KITITAS COUNTY

MEMORANDUM

TO: All Staff
FROM: Justin Turnbull, County Surveyor 
DATE: May 8, 2019
SUBJECT: County Survey Review of BLA BL-19-00006 Capps

SHEET
1
OF
2

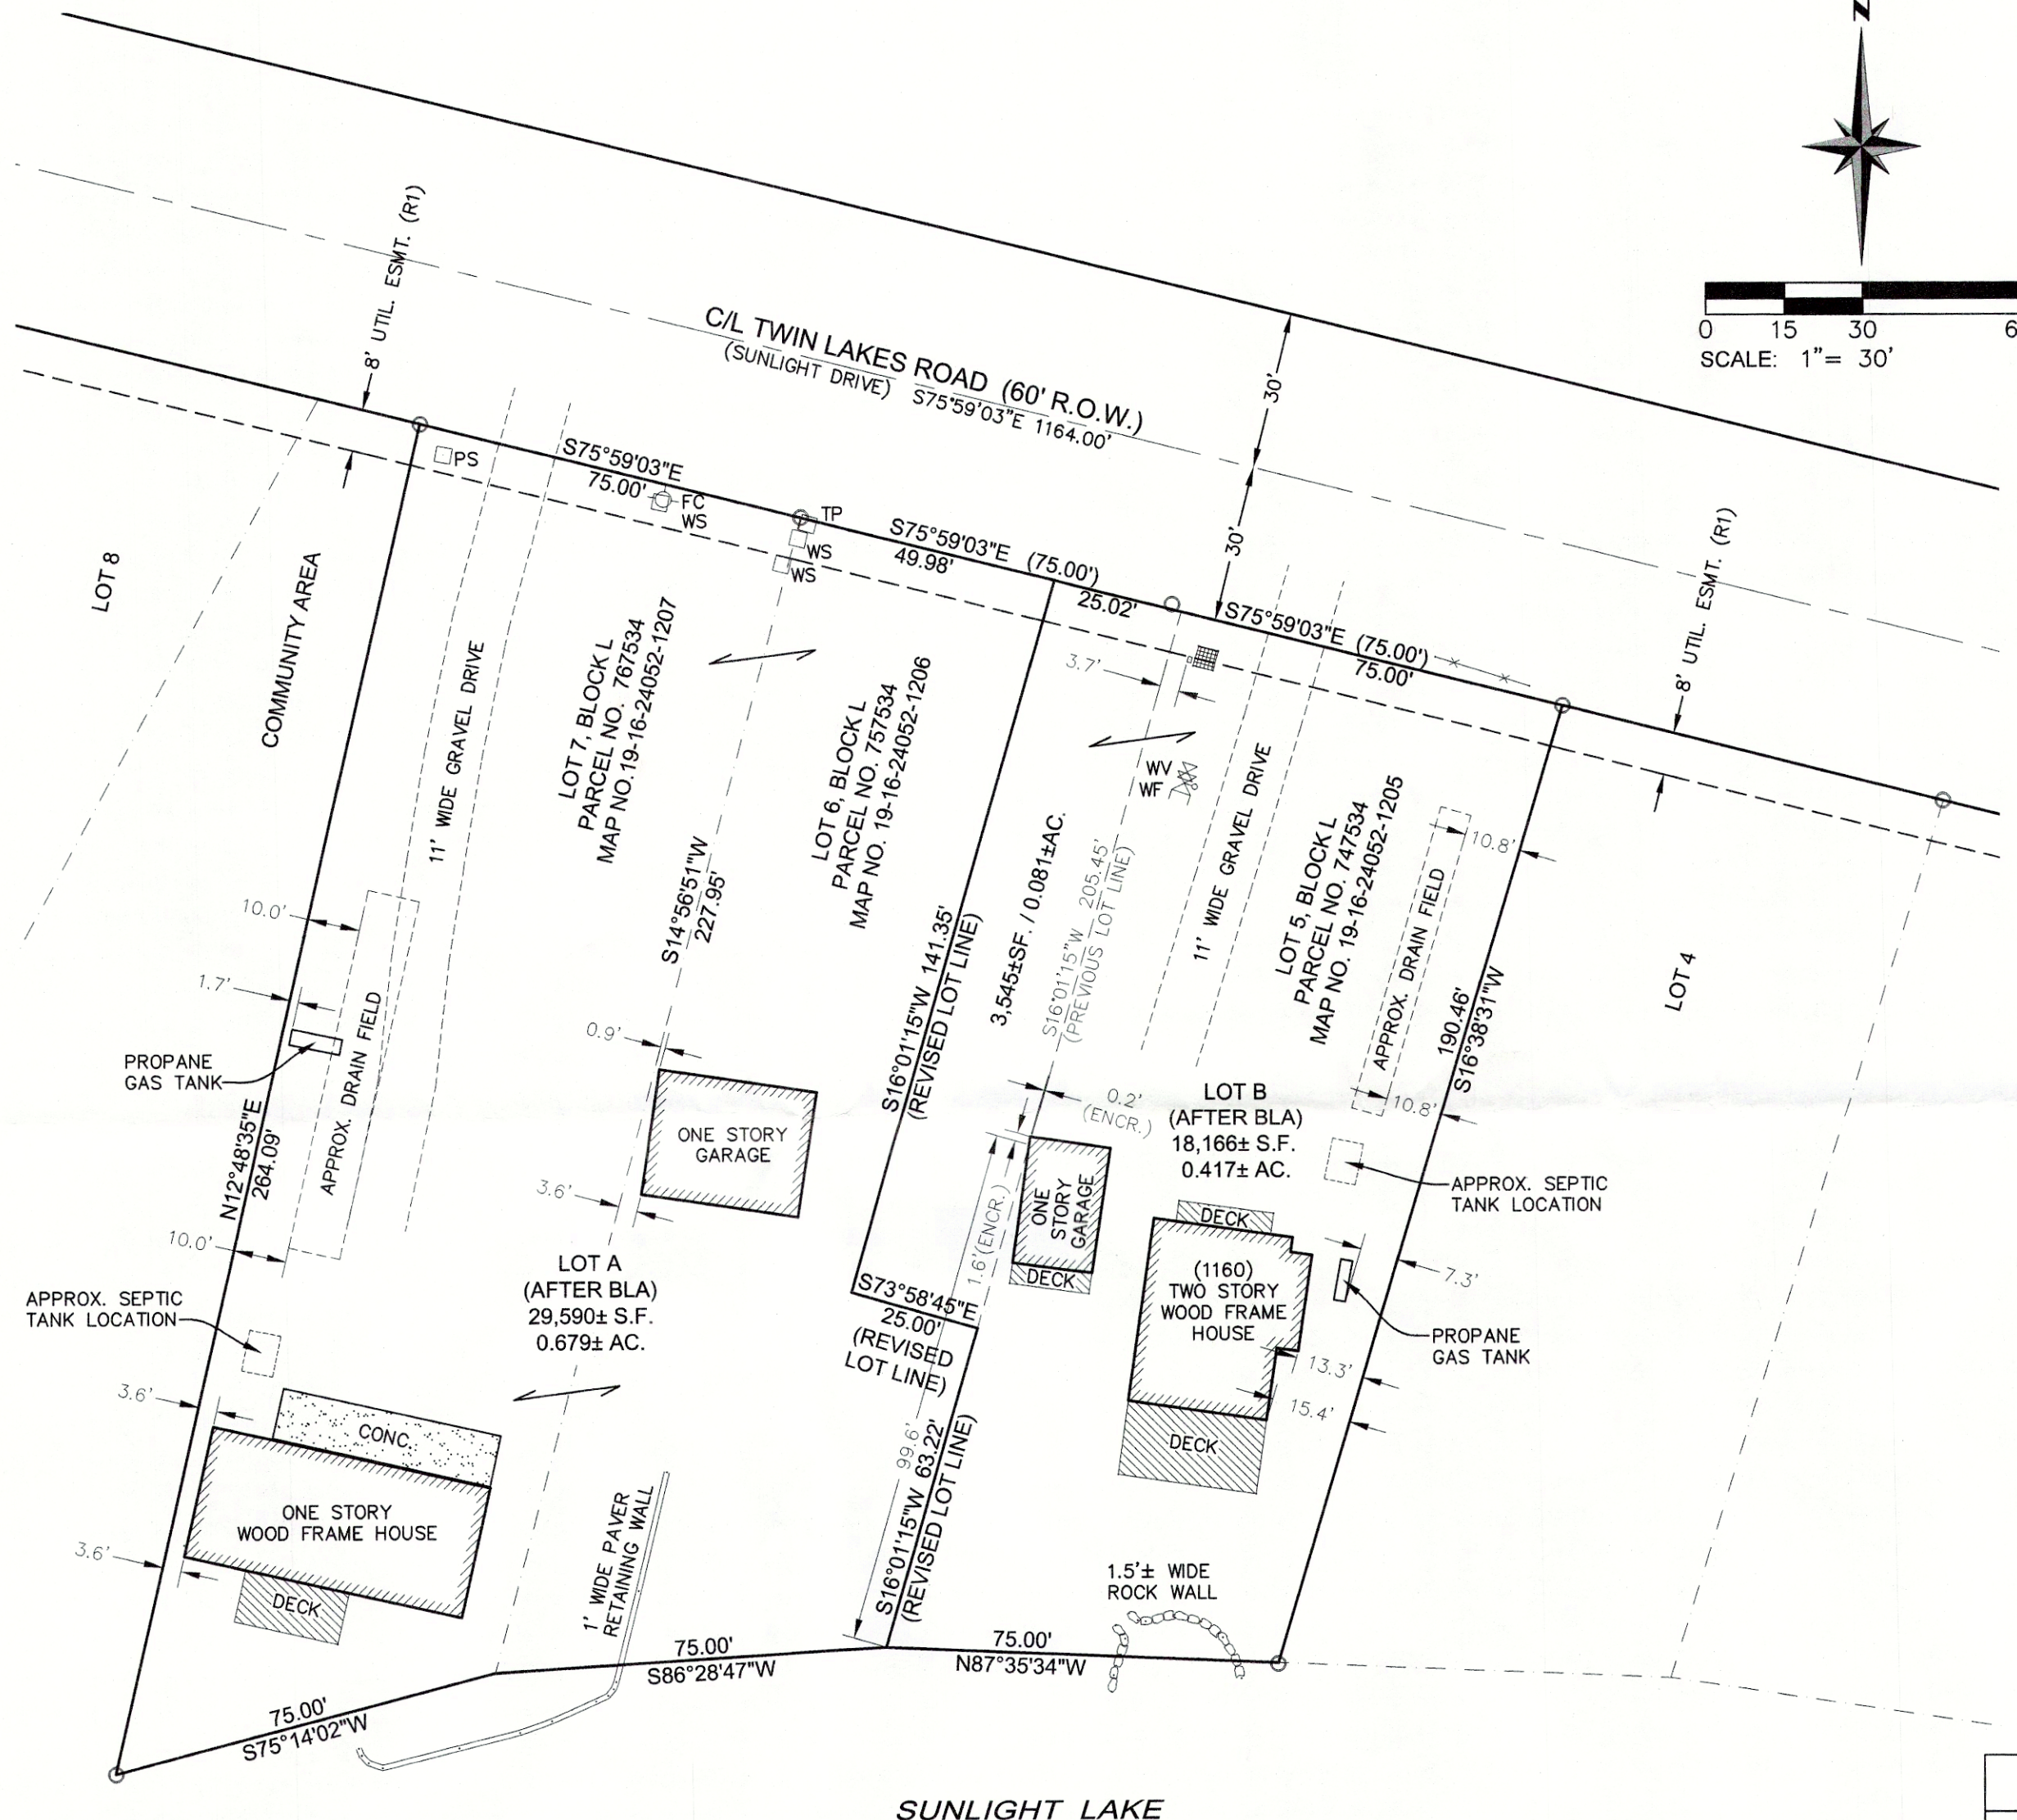
1. As a minimum, the new division line should be staked in the field, and noted on the face of the map.
2. It appears that the map uses greyscaled linework. The applicant is reminded that grey scaled linework is not suitable for the final documents to be recorded.
